Your Ref: OWPC7312
Our Ref: A/139/15/HH 25-09-2015
Please ask for:
Andrew Wood

Loft conversion
Dovedale West Drive Angmering

Thank you for your internet representation made on 1st November 2015 which has been recorded as '**an objection**' with the comments as follows:

Loft Conversion Plan

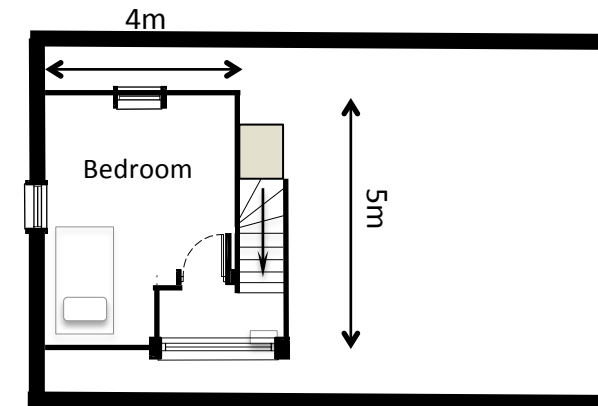
Side-facing window. The side facing window would look directly at the rear of our house and overlooks all our habitable rooms: main bedroom, children's bedrooms, living room, kitchen, conservatory and children's study/playrooms. It is not clear from the application whether this window would be non-opening or opening. I see that it is described as being made frosted but there is no statement as to the percentage opacity that is being contemplated.

Rear velux window. The proposed velux window overlooks all our main habitable rooms, particularly the main bedroom and our children's bedrooms which is unacceptable to me. The window would also overlook our garden and would considerably reduce my family's privacy. The orientation of our garden is such that the window would overlook the section of the garden that we use most.

I would like confirmation that the opacity of the side window would be the maximum possible and that it would be non-opening to maintain our privacy.

I would like the rear velux window to be removed from the plans altogether as it has a substantial impact on our bedrooms privacy and also whilst using our garden.
